Our ref: DOC22/152623

Your ref: SSD 17655146

Subject: EES Response to Environmental Impact Statement - Taronga Wildlife Hospital Nutrition Centre (SSD-17655146)

Figure 7 Shows tree 9 and point cloud assessment of branches conflicting with proposed Nutrition Centre

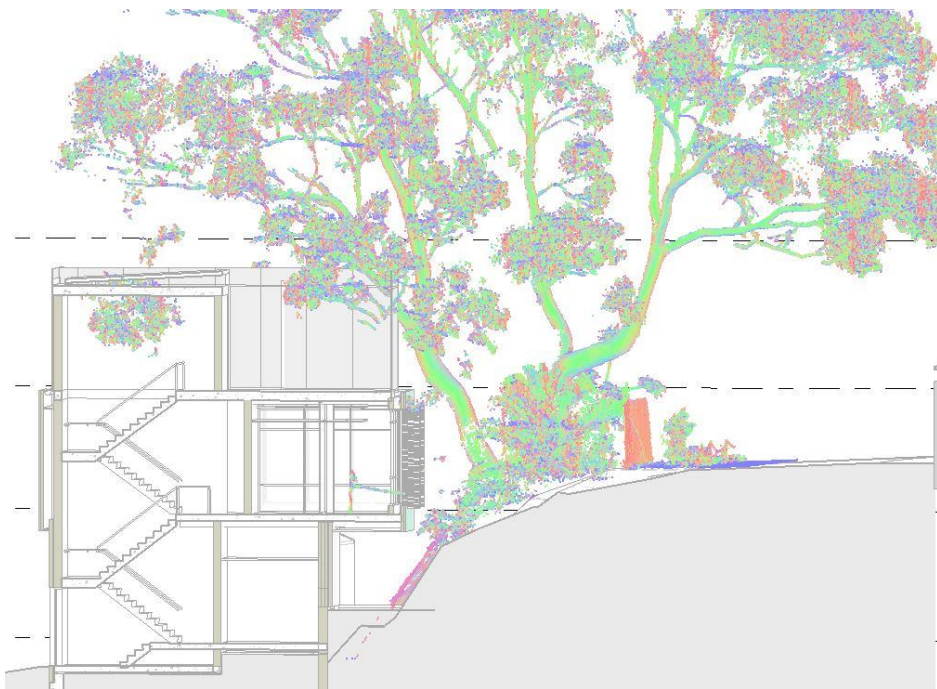
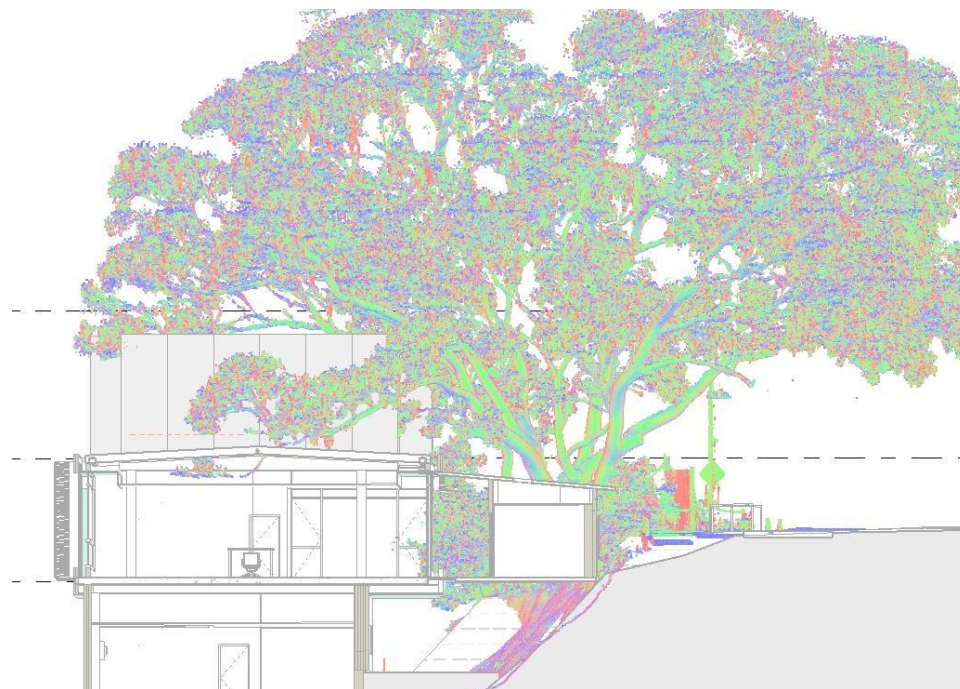
- A Point Cloud analysis has been provided to demonstrate the pruning requirements of trees 9, 10, 11 and 14 however EES notes figures 7 and 10 of the report only relate to tree 9. The proposed pruning works to the subject trees contribute substantially to the recommendation for removal. Further clarity around the specific extent of impacts to the canopy of these trees should be included in the report. If any slight adjustments to the building position or height would reduce these impacts, this should be discussed.
